# Mellor Parish Council

**Planning Application 3/2022/1055 59 Mellor Brow, Mellor Blackburn BB2 7EX**

Proposed front porch and front dormers. Two storey rear extension and material changes.

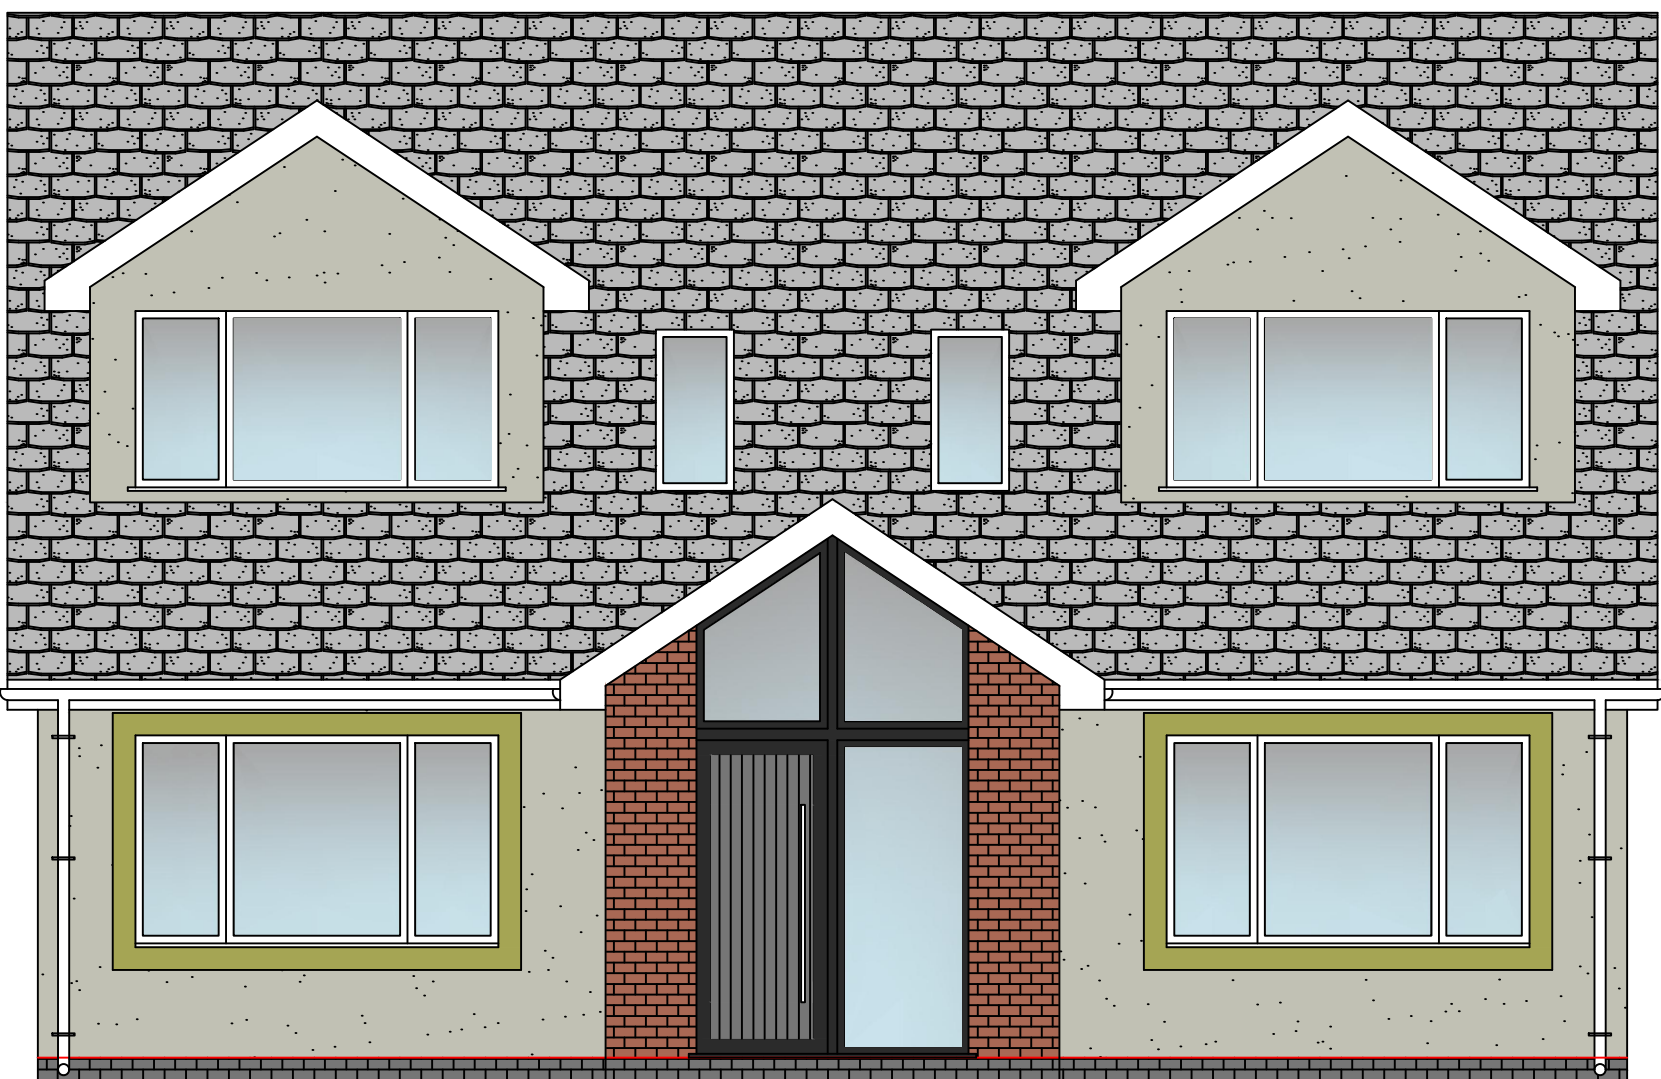
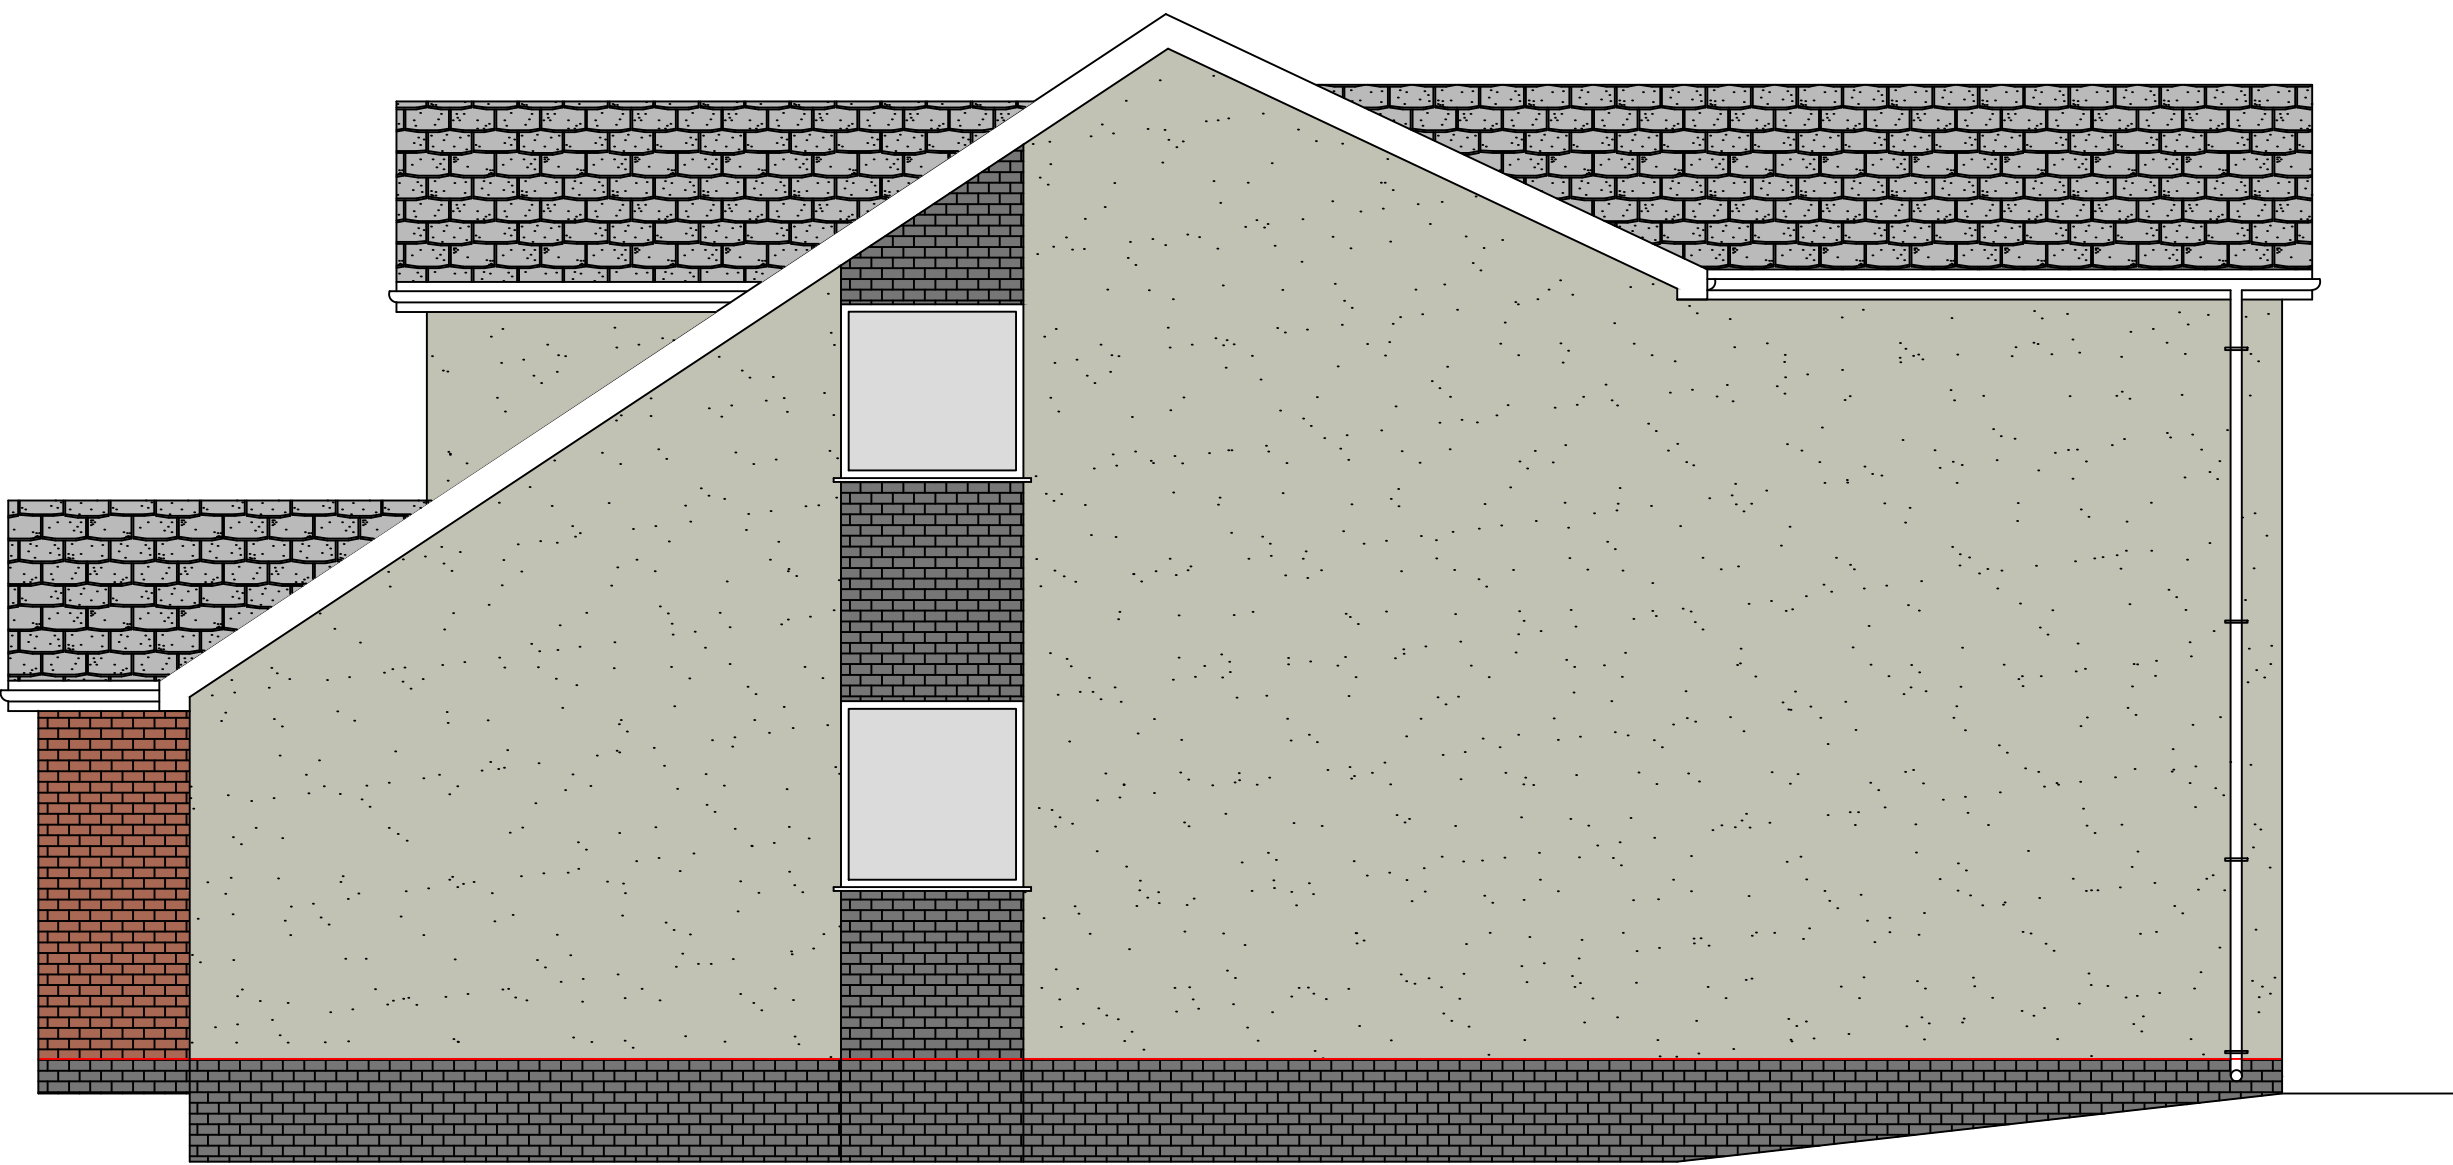
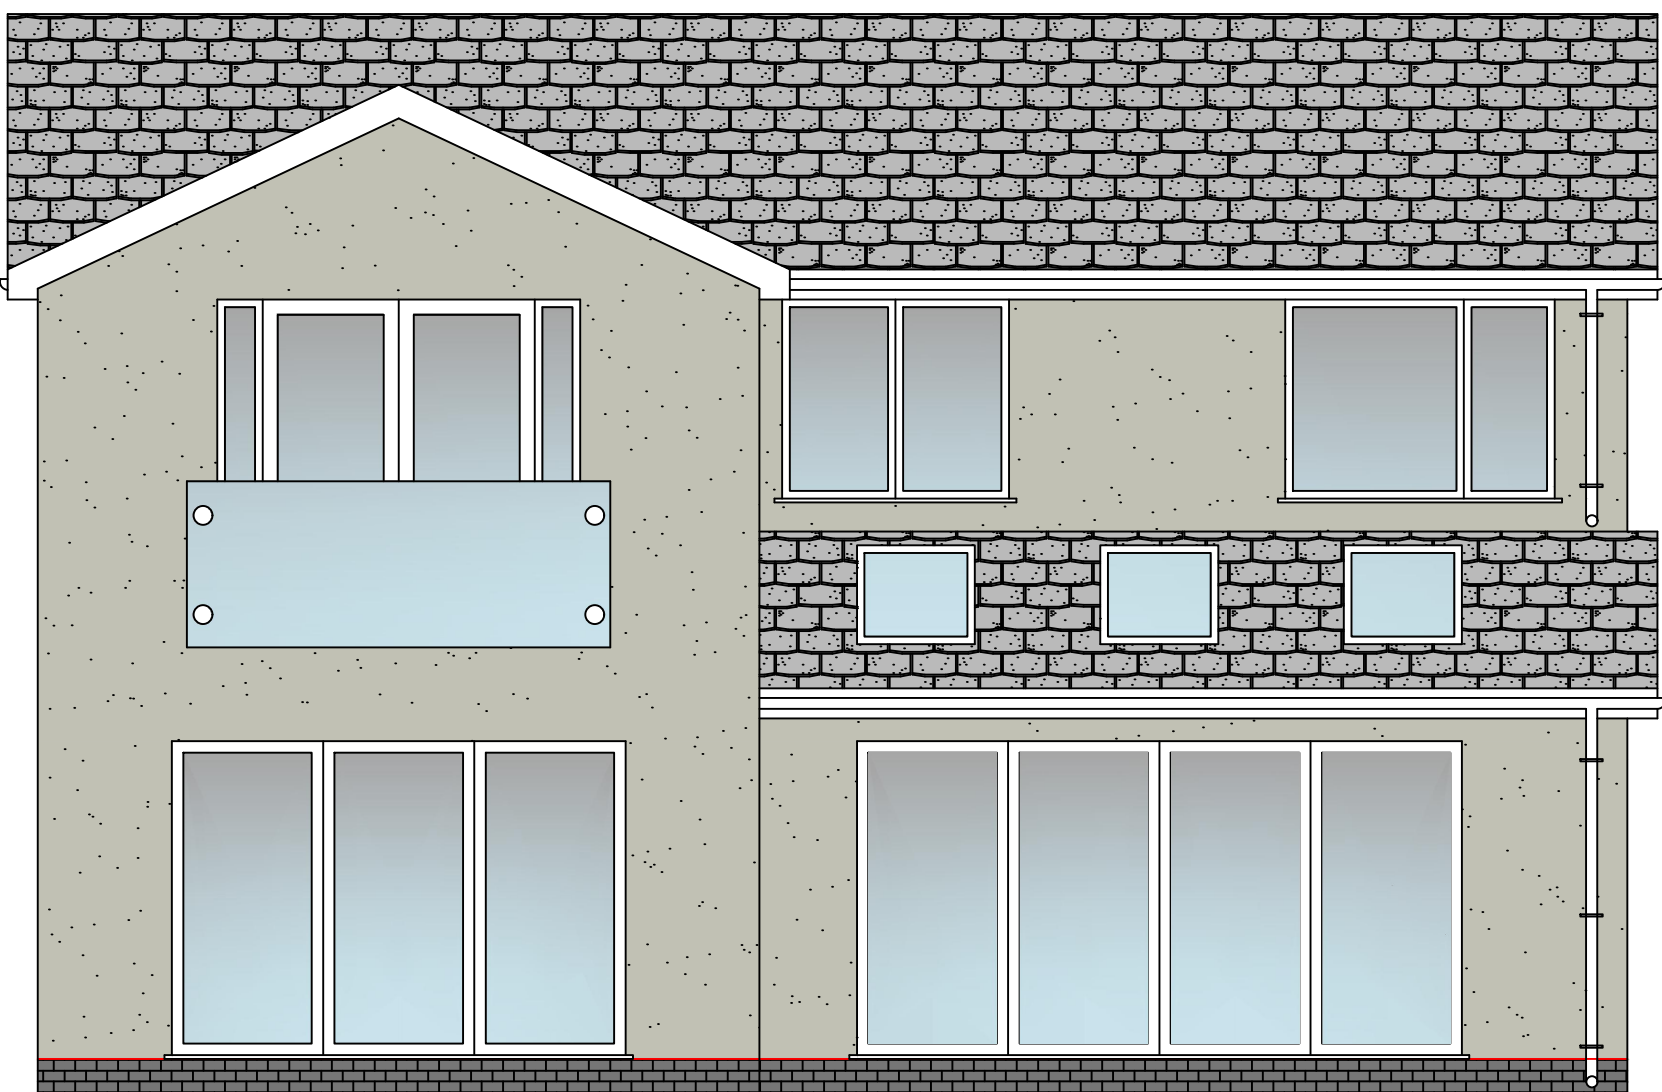
It is considered that, due to the size and scale of the proposals within the application as it stands, it is overbearing in scale which would lead to a loss of light & privacy for the neighbouring residents.
